Consultation Response from KC Landscape

Application No:	2023/93667
Proposed Development:	Outline application for demolition of buildings and erection of residential development (up to 261 dwellings), redevelopment of Lodge Cottage for residential use and associated works
Location:	Storthes Hall Student Village, Storthes Hall Lane, Kirkburton, Huddersfield, HD8 0WA
Applicant/Agent:	Johnson Mowat
Planning Officer	David Wordsworth
Date Responded:	22.02.2024 now 26.02.2024 now 23.05.2024
Responding Officer:	EM
Responding Ref:	MM119

New comments based on draft Amended layout information received 13.05.2024.

Site Layout Plan with Tree Root Protection Areas - Scale 1:1000

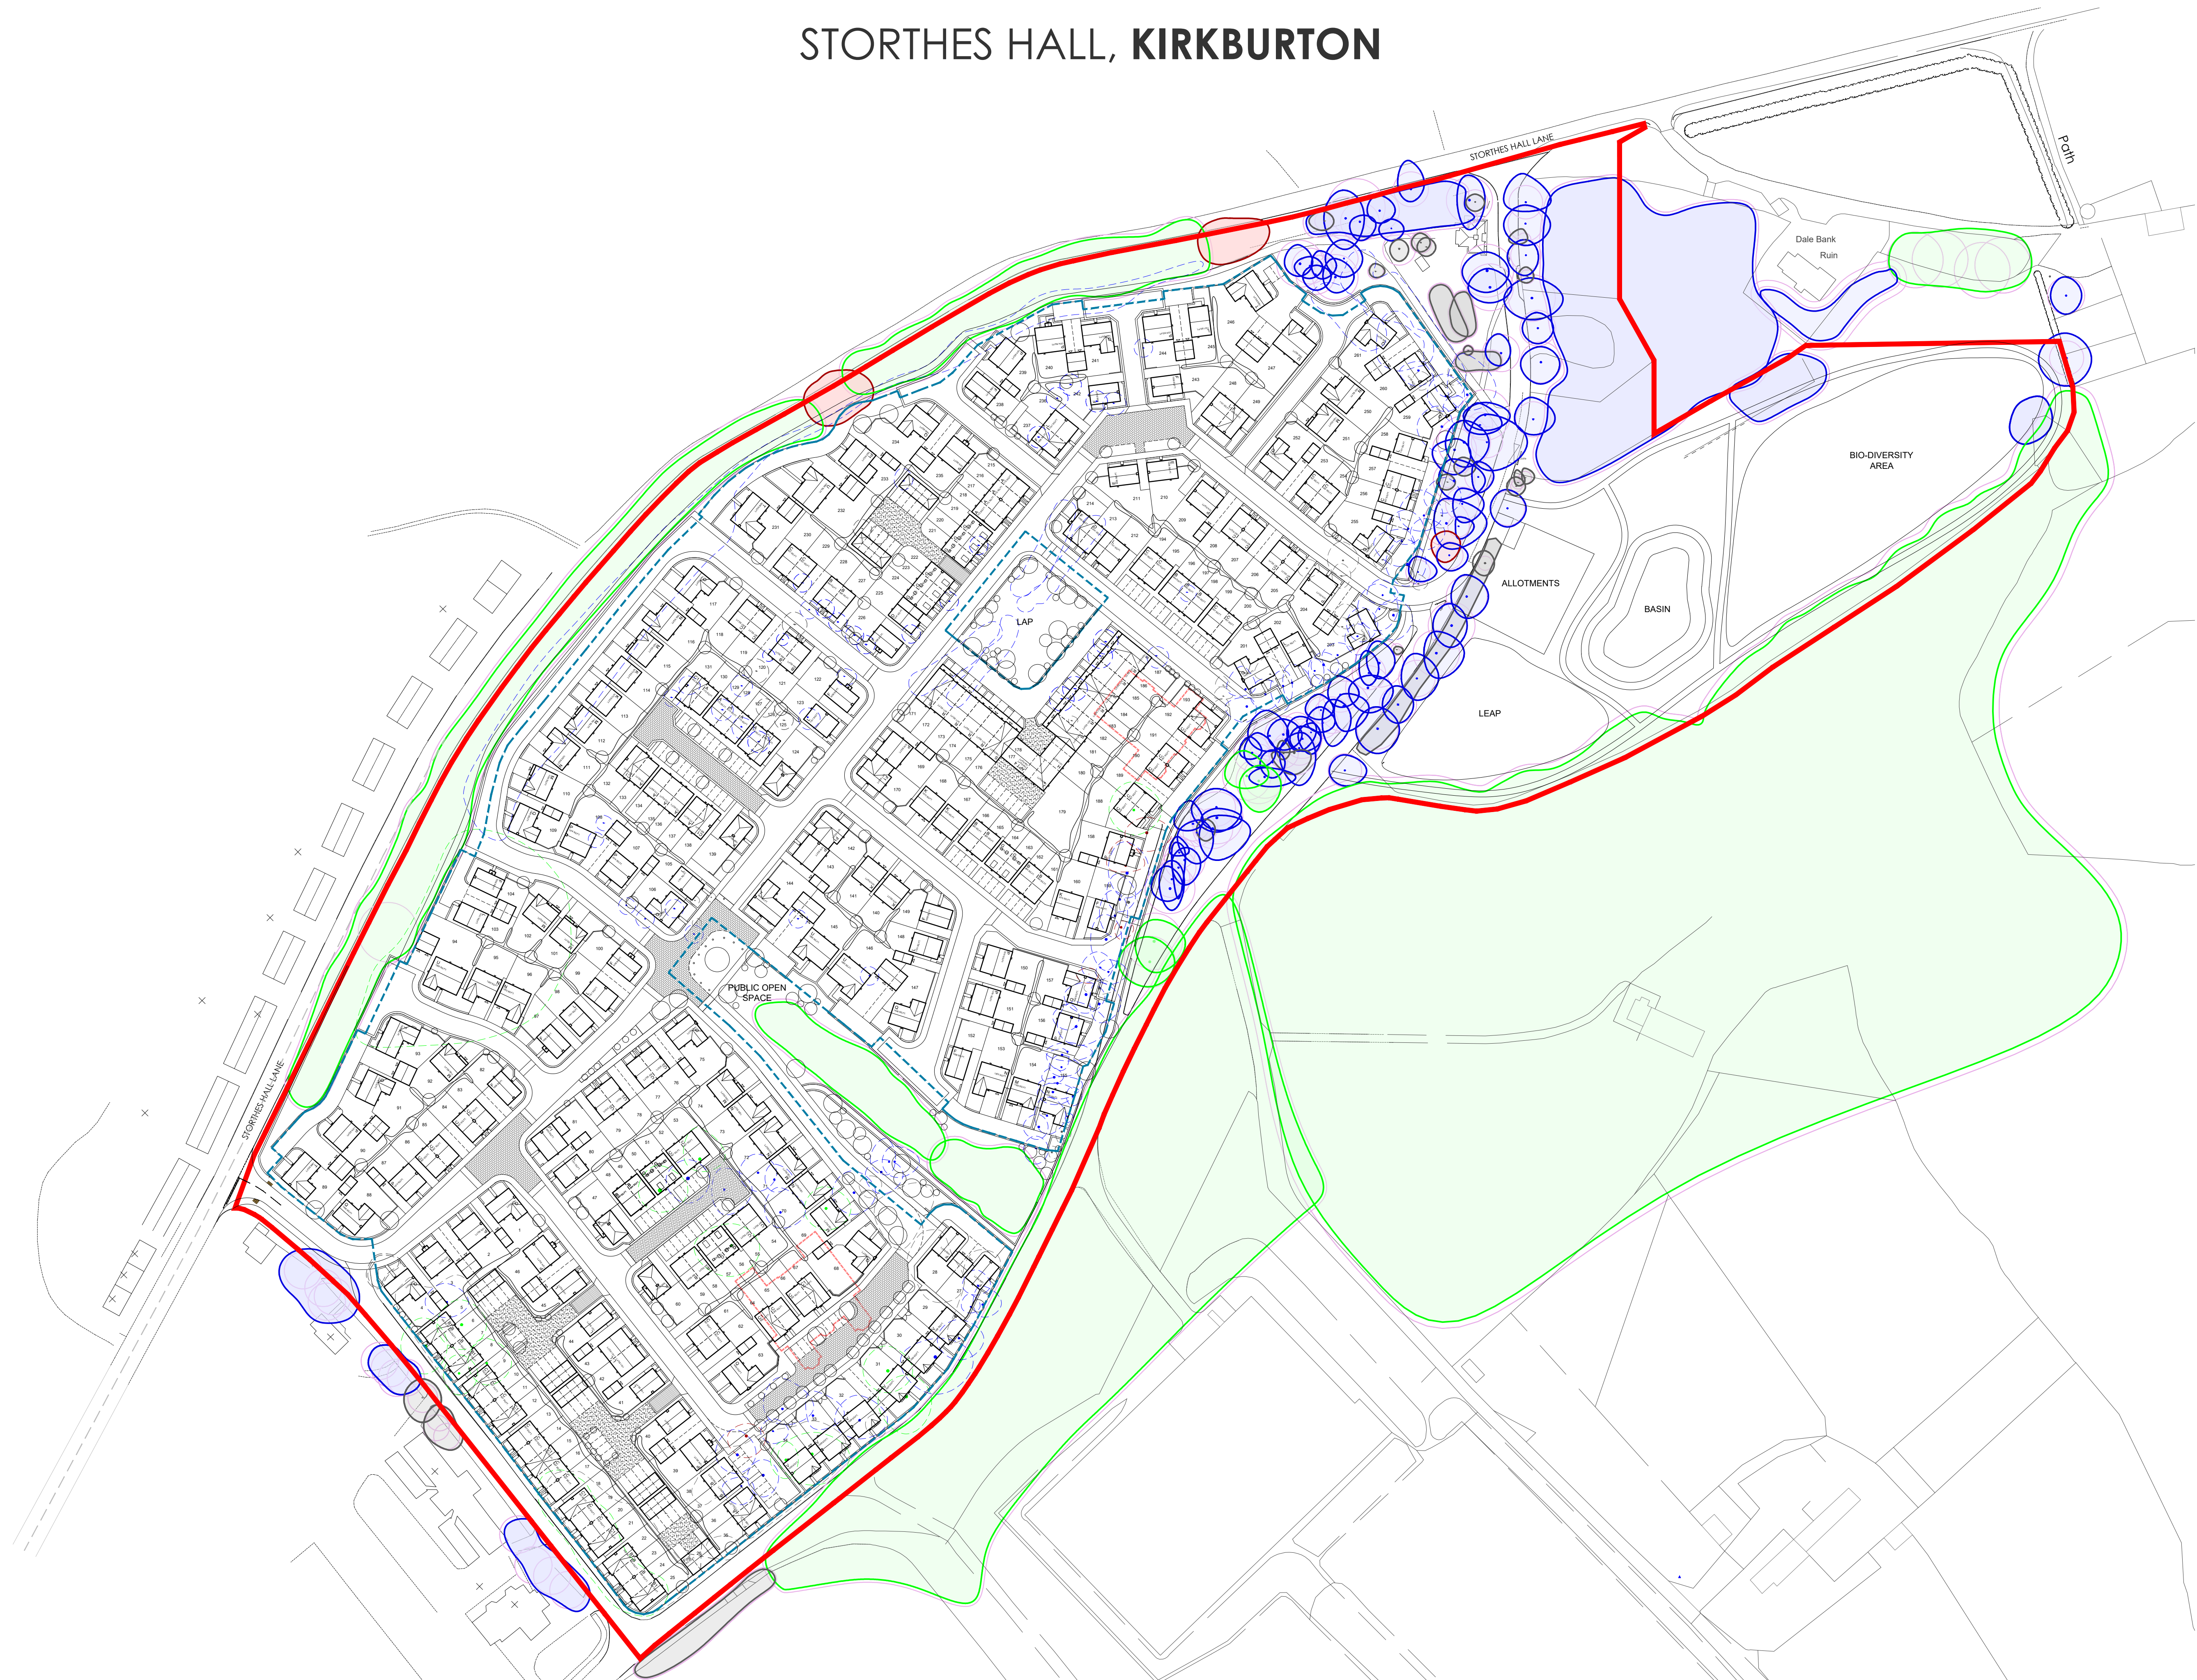
1. Query over the location and creation of this public open space around the tree retained, however the tree report states this tree as removed as indicated on plan 1337-003-ENZ-XX-00-DR-AR-45-103? Clarification required.
